**Comments on Other Submissions  
(submitted at Deadline 5 and 6)**

**for the  
Royal Society for the Protection of Birds  
and Suffolk Wildlife Trust**

**Submitted for Deadline 7  
3 September 2021**

**Application by NNB Generation Company (SZC) Limited for an Order  
Granting Development Consent for  
The Sizewell C Project**

DRAWING NO:
SZC-SZ0100-XX-000-DRW-100205

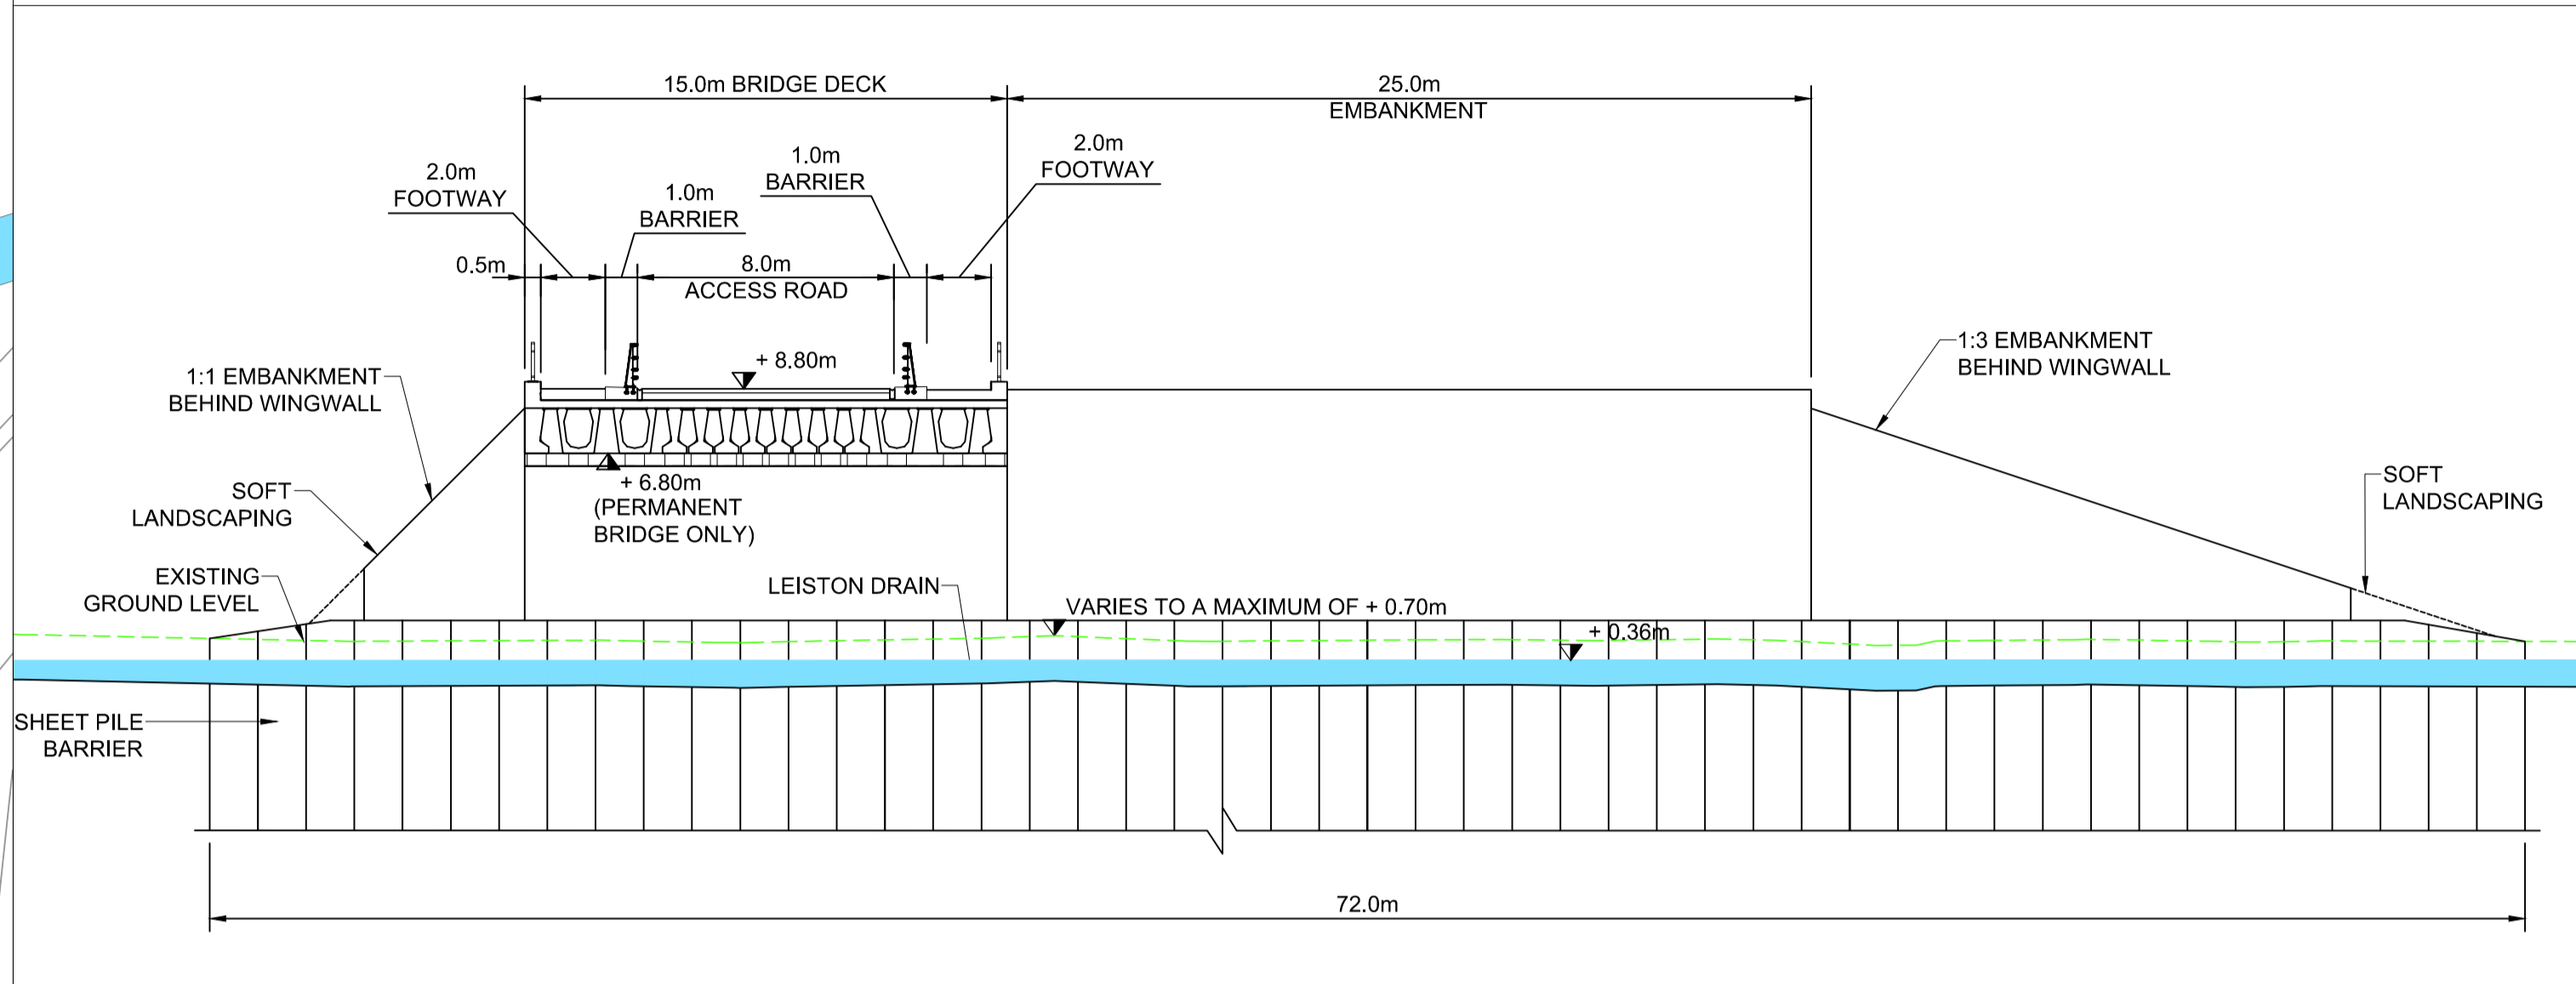
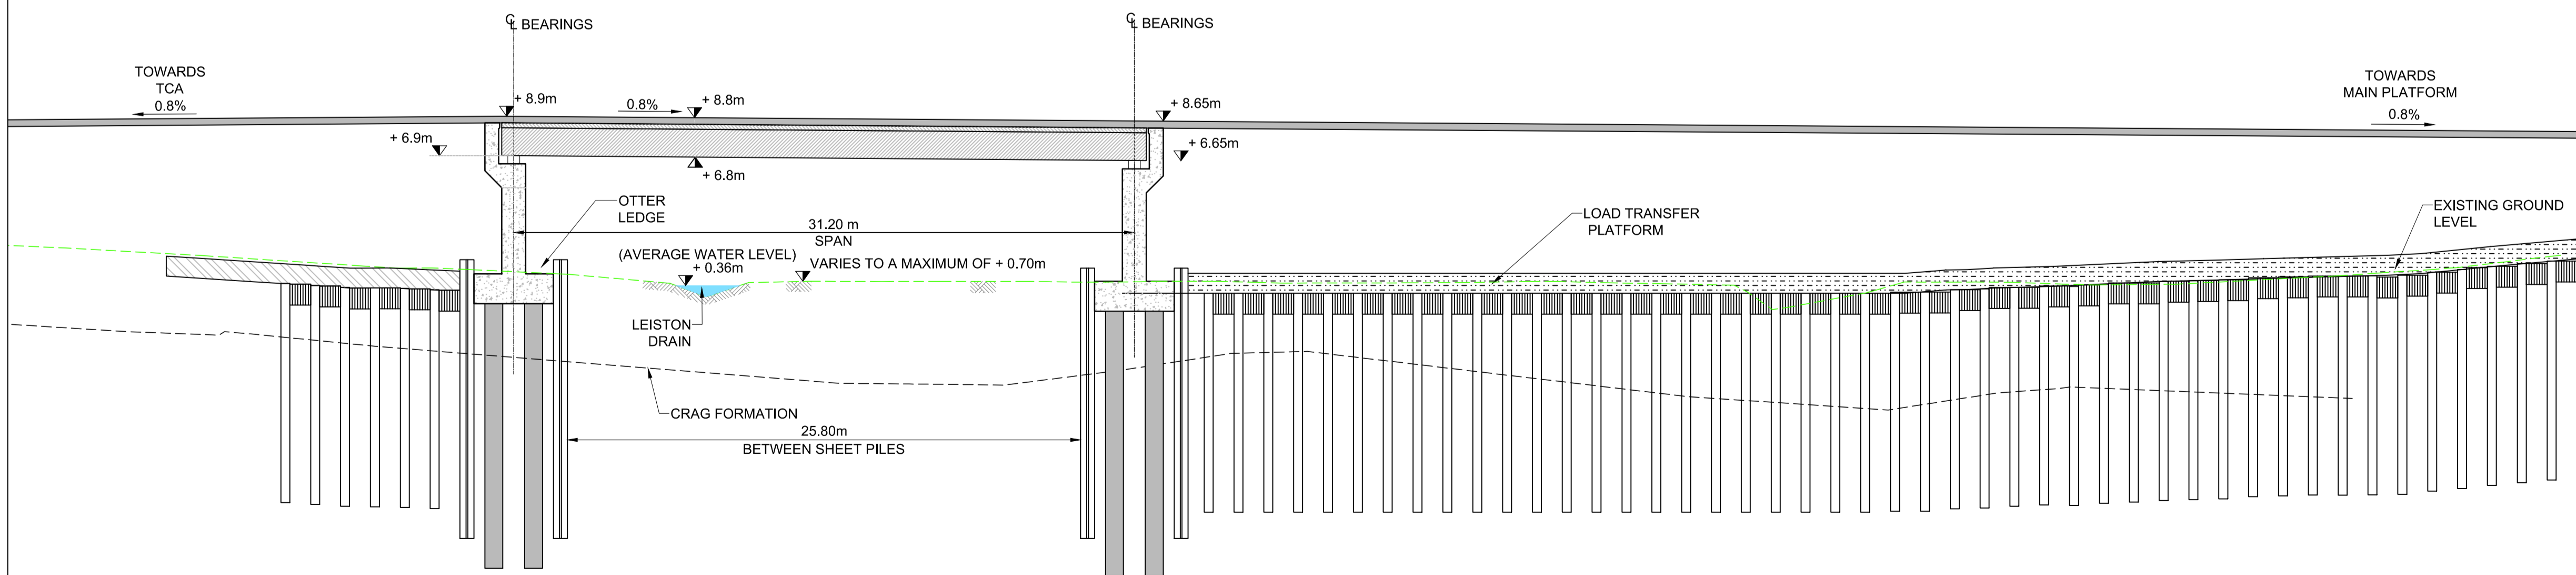
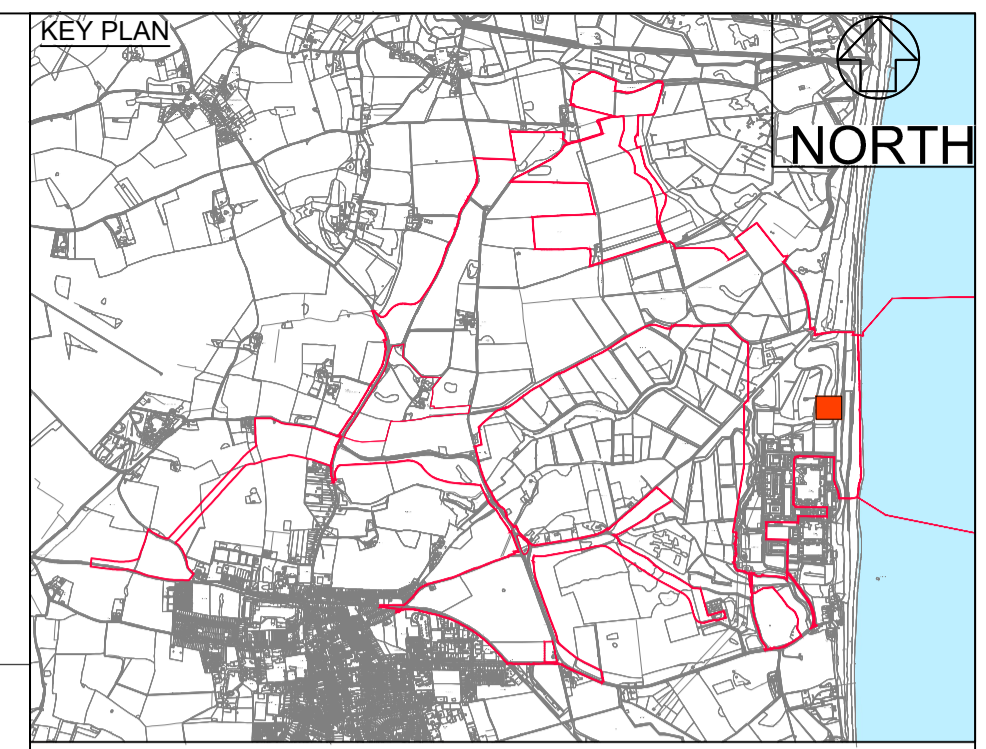
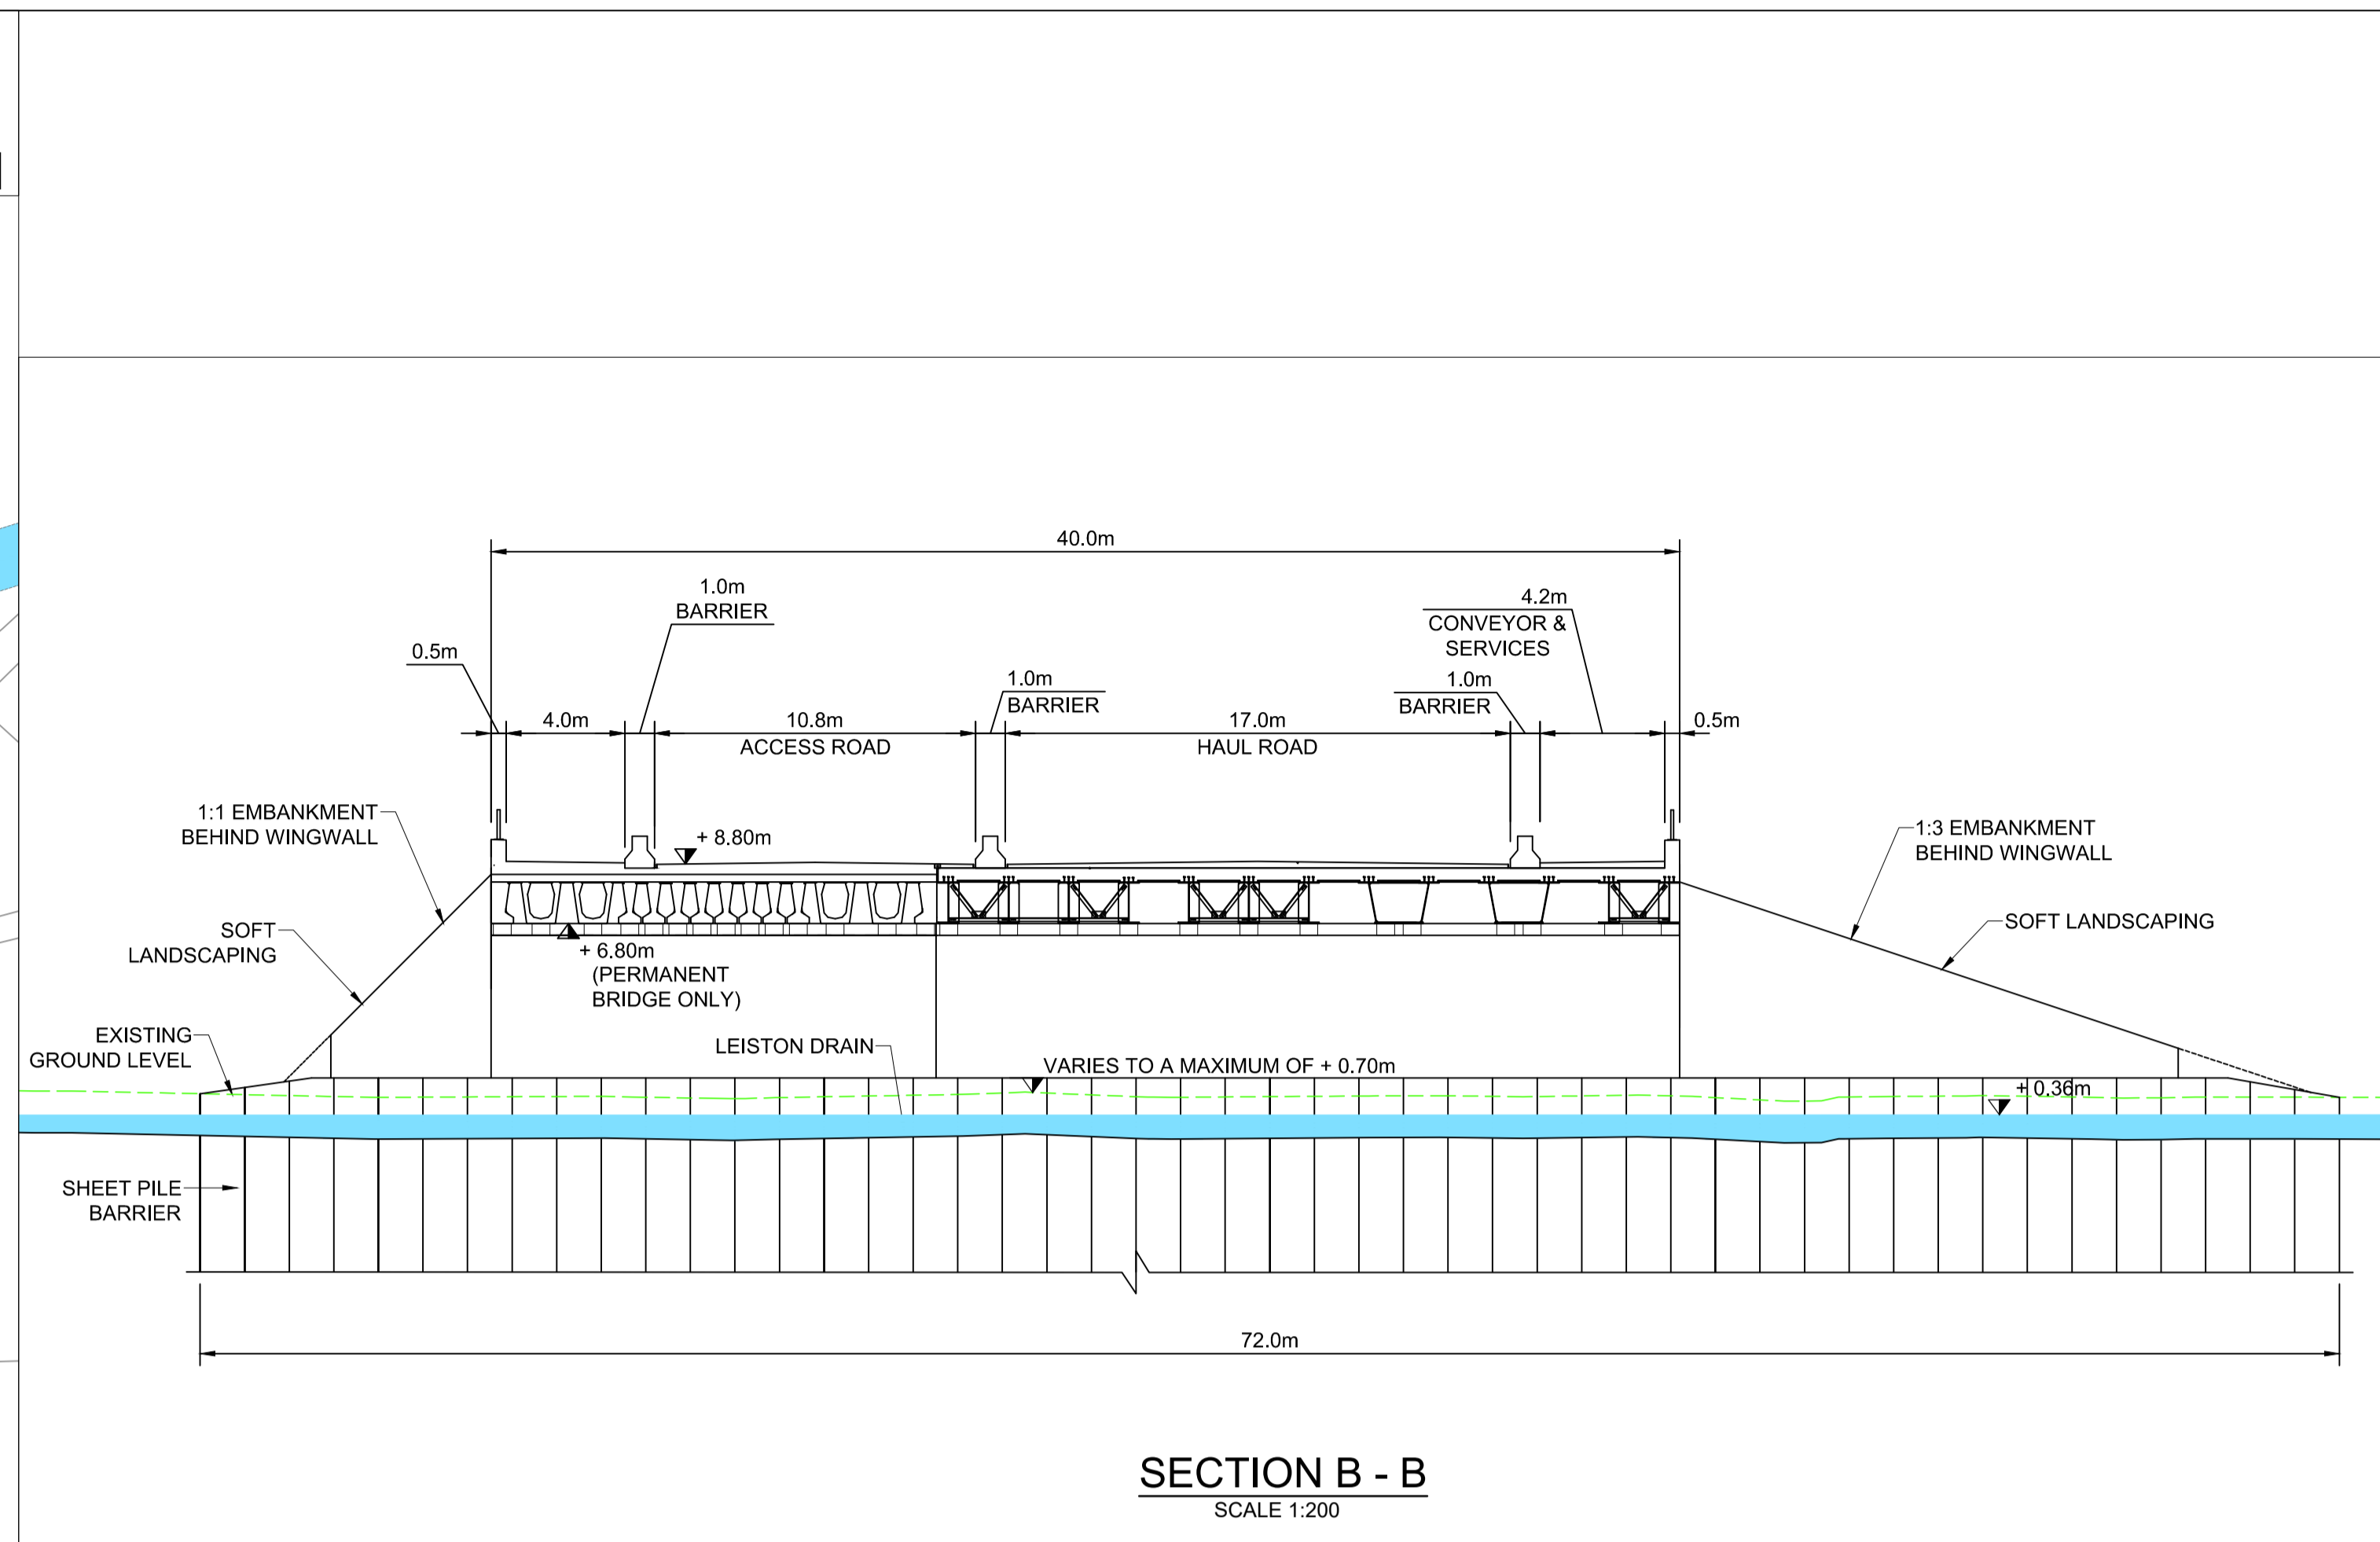
4.17. We note the Applicant has provided a drawing showing the SSSI landtake and SSSI area beneath the permanent bridge for the triple span bridge option and the proposed design (July 2021).

4.18. We do still consider the triple span bridge to be the best option to minimise SSSI land take and habitat fragmentation as we have stated previously<sup>26</sup>.
